from
**Southern
Water**

Our ref
PLAN-032669

Proposal: Approval of details reserved by condition imposed under ref LU/47/11 relating to Condition Nos 10 - surface water drainage, 13 - foul drainage, 15 - tree protection, 19 - ecology, 20 - ecological management plan, 21 - ecological management plan, 22 - Construction Method Statement, 23 - construction compound, 25 - vehicle & highway cleaning, 31 - decentralised & renewable energy, 37 - noise mitigation and 40 archaeology.

Site: LU/90/20/DOC: - Land South of Toddington Lane, Littlehampton, BN17 7PP.

Porous Block Paved Construction with Tanked Porous Sub-base.

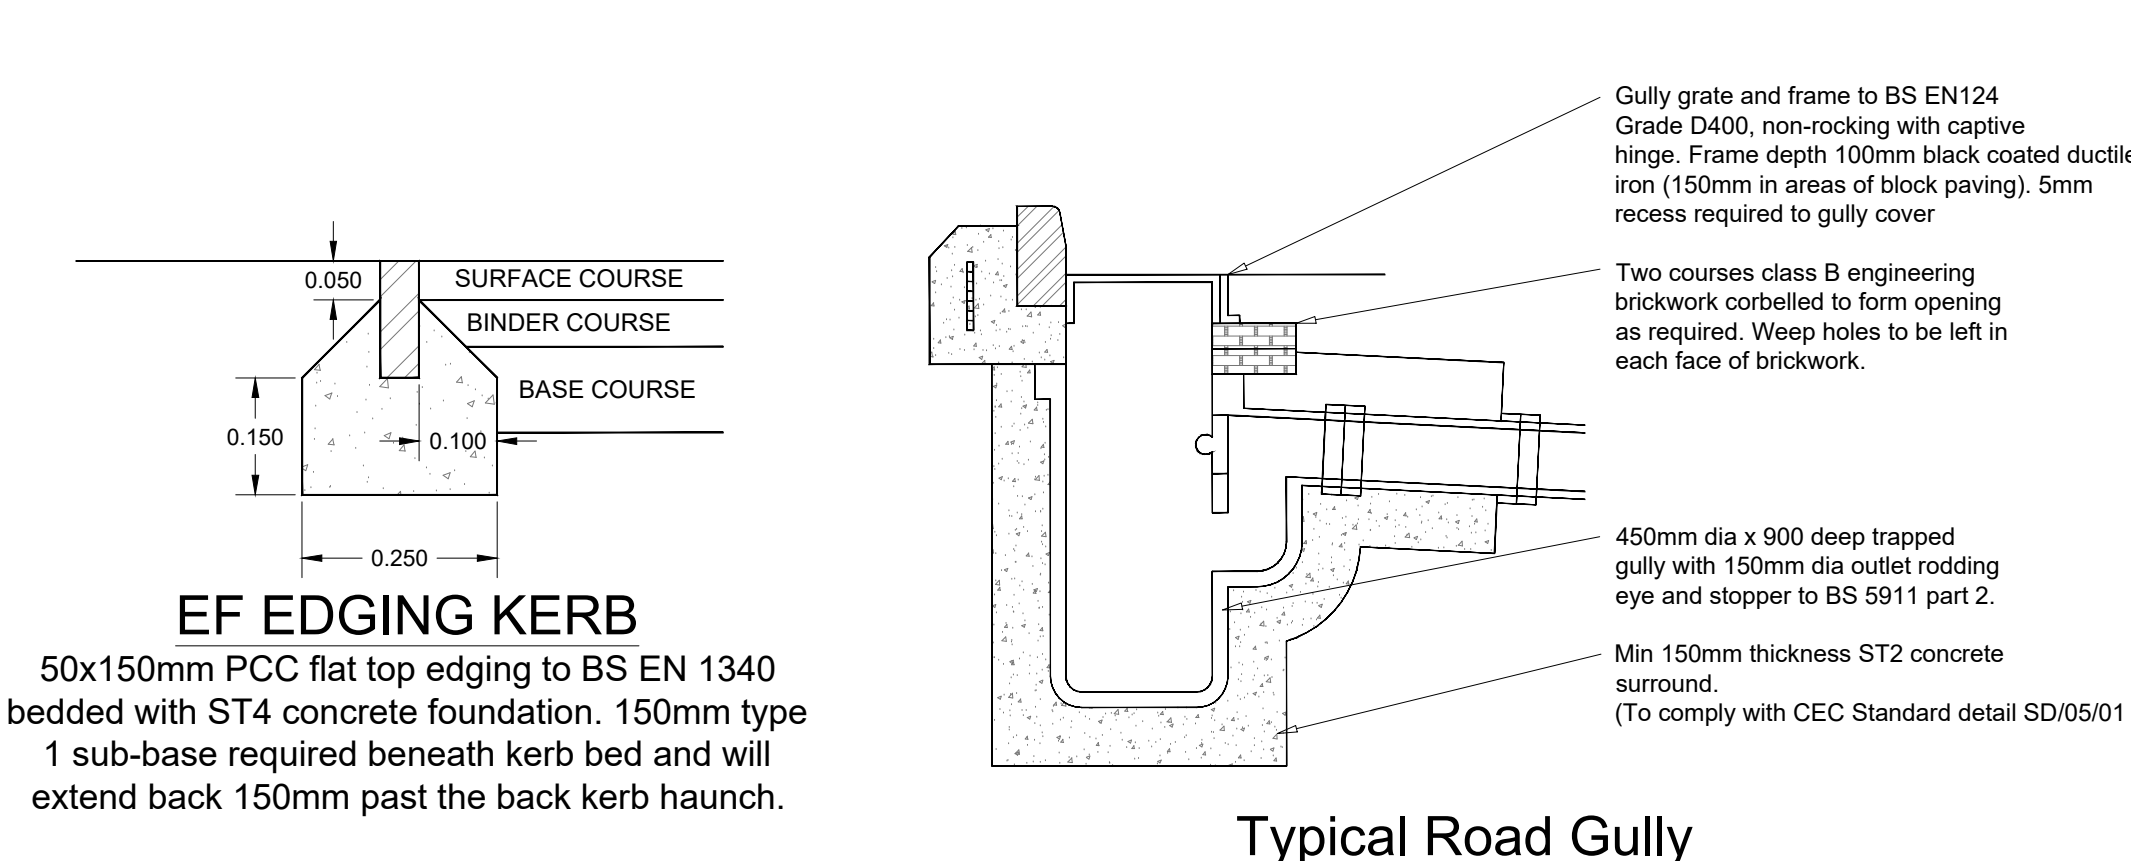
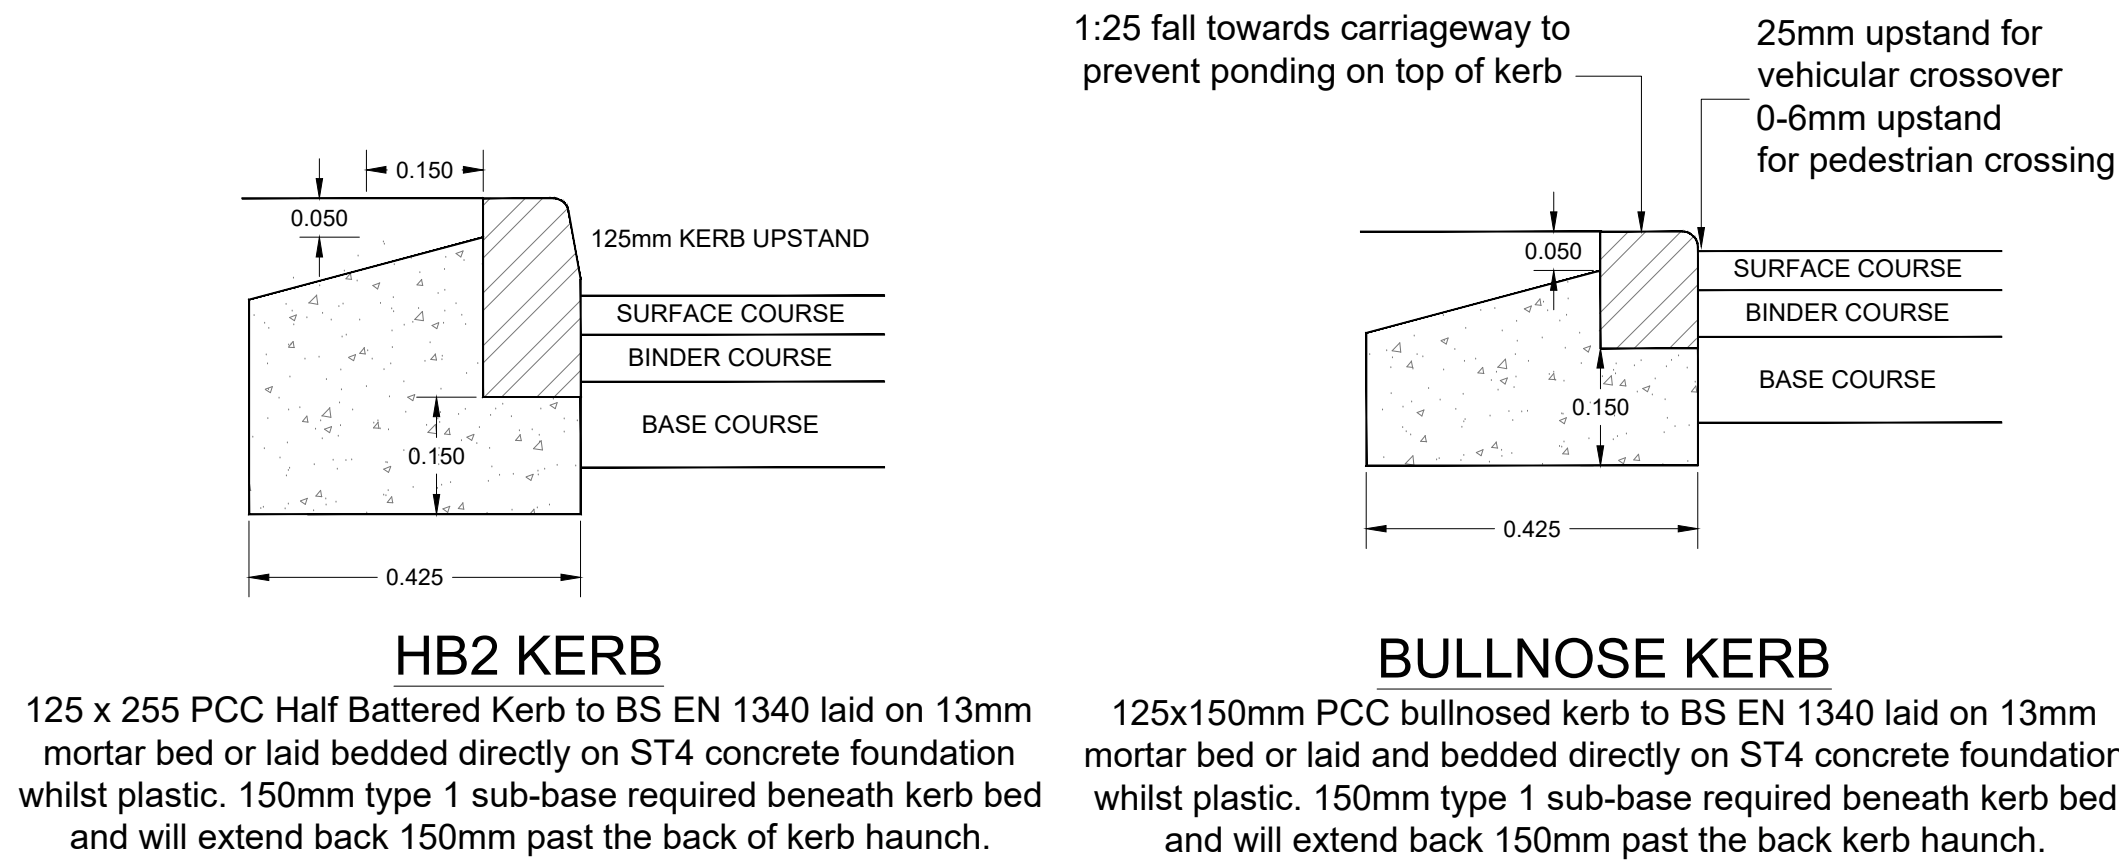
Also, the construction of tanked permeable paving over or within 5 meters of public or adoptable sewers is not acceptable to Southern Water.
